# Development Review Checklist

Level I / **Level II** / Level III / Master Plan  
 Project Name: Luminato  
 Address: 169 Newbury Street  
 Description: Alteration / Addition / **New Construction**  
 Date Received: 03/28/16 Prelim / **Final**  
 Planner: Caitlin Cameron

## Final Review Comments for 169 Newbury St - Luminato

Re: 169 Newbury St – Luminato Condominiums

8 TYPICAL BACKFLOW PREVENTOR DETAIL
NOT TO SCALE

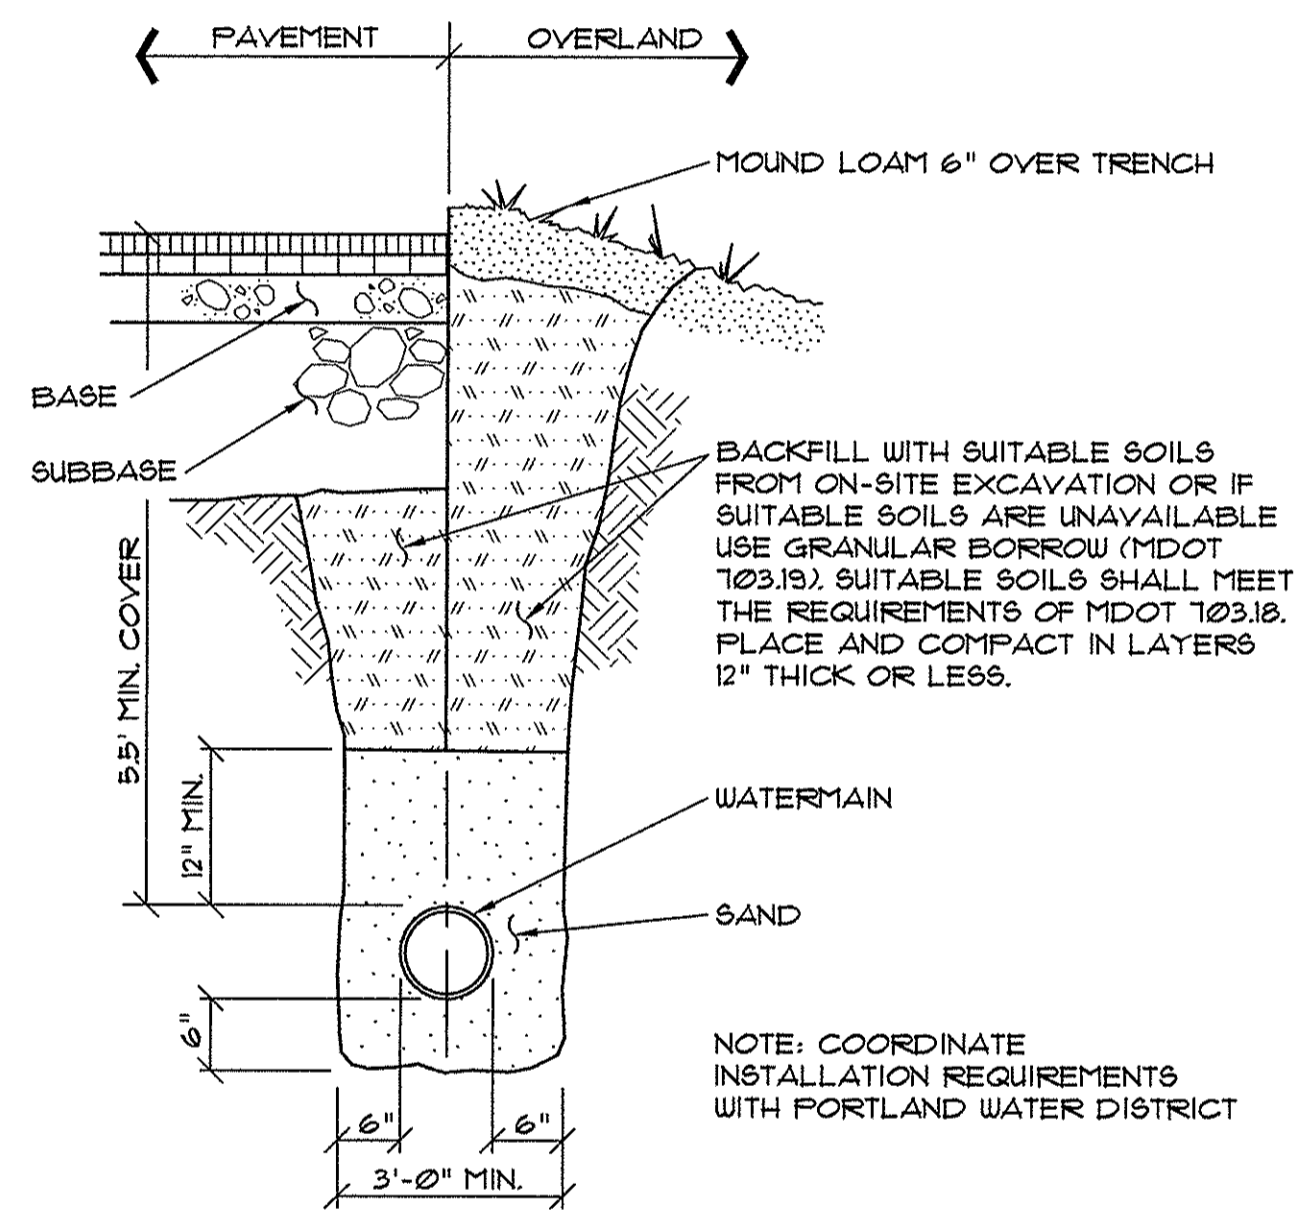
8. Since the sewer systems are separated, a backflow preventer on the sanitary lateral is not required by the city. If the applicant wishes to install one, please place the backflow preventer on the applicant's property.

**Issued resolved. The backflow preventer has be eliminated.**

**5 BITUMINOUS DRIVEWAY APRON (I-13)**  
NOT TO SCALE

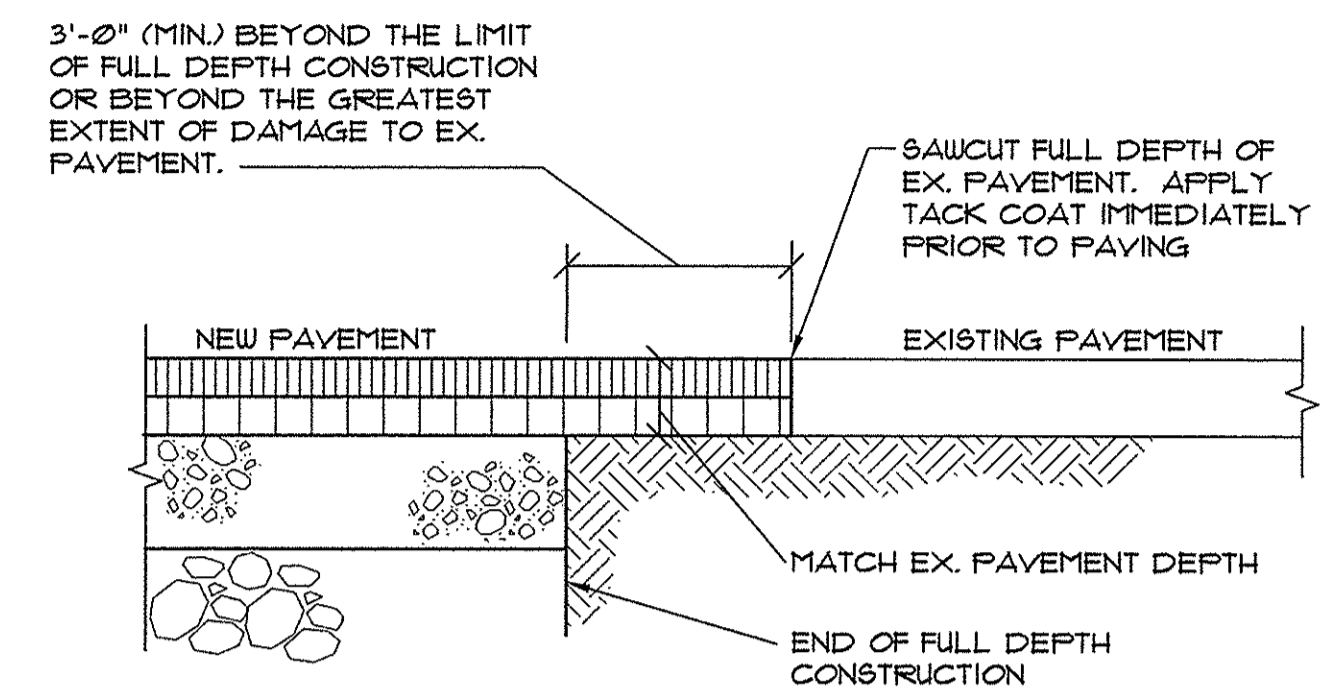
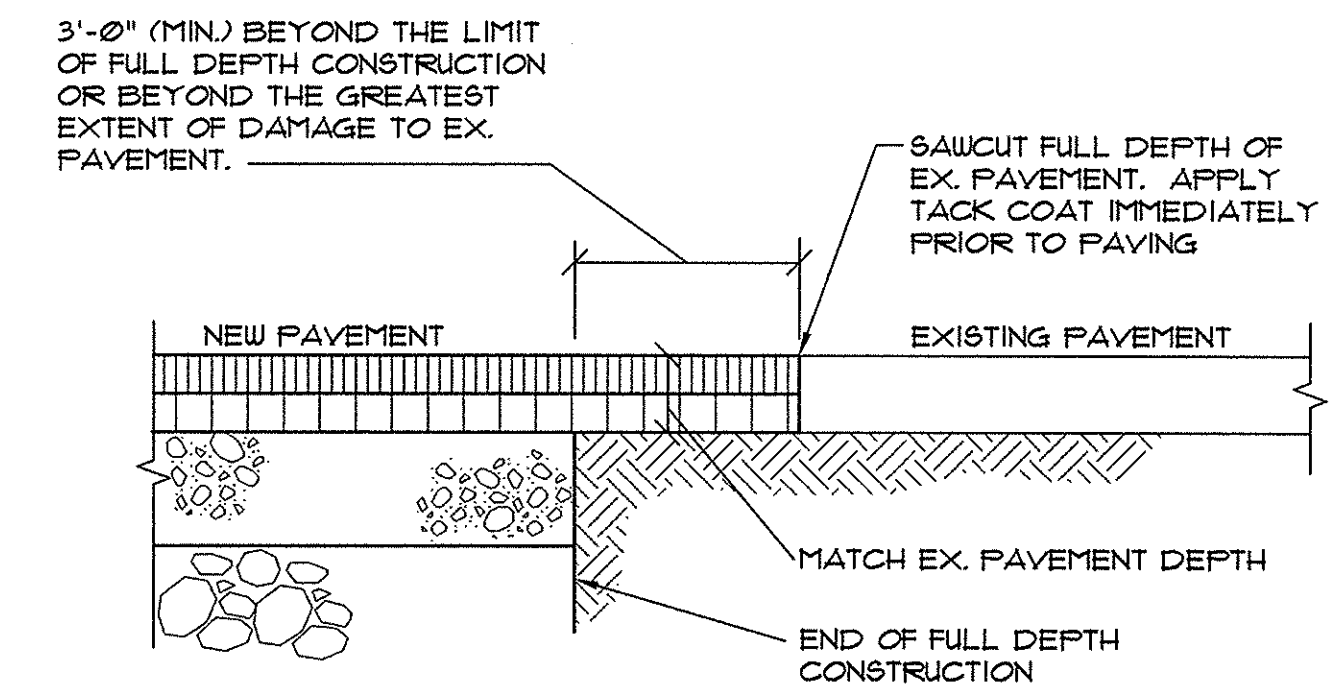
- The driveway apron on Newbury Street shall be designed so that a maximum 2% cross-slope is constructed for pedestrians walking along Newbury Street.

5. The applicant is showing a brick driveway apron within the street right of way on Newbury St.

This is a deviation of the City's material policy which calls for an asphalt apron. This department is supportive of a waiver request however the applicant will need Council approval and signoff on maintenance agreement of the drive apron within the road right of way.

**Final Status: A note has been added to the plan and I find it to be acceptable.**

**Drive aprons have been changed to asphalt.**

5 CATCHBASIN #2 SECTION (II-2) NOT TO SCALE

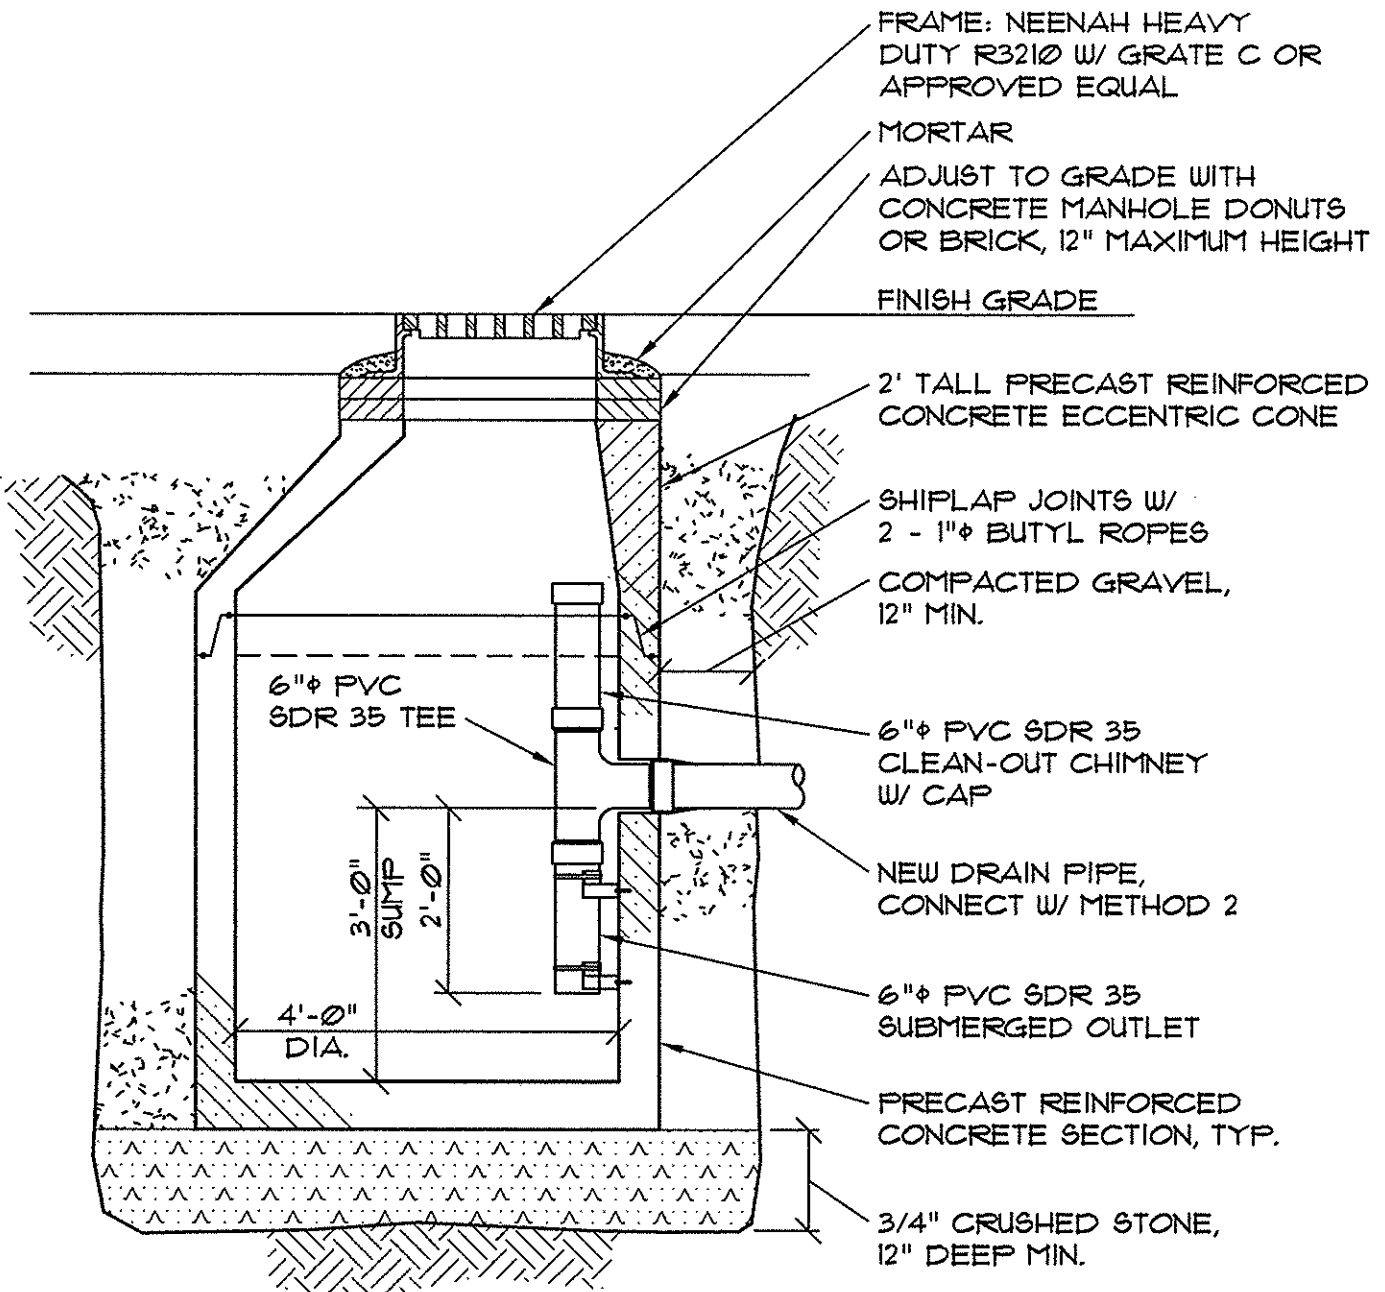
4. It is understood that all roof and site drainage will be directed to proposed catchbasin #2 in Newbury St. or to the ground and not the sanitary sewer system. Please confirm that this is the case. Please note that N-12 is not permitted within the street right of way. Please consult Chapter Two of the City's Technical Manual for acceptable pipe material options.

**All site drainage will be conveyed to Hampshire St and N-12 will not be used.**
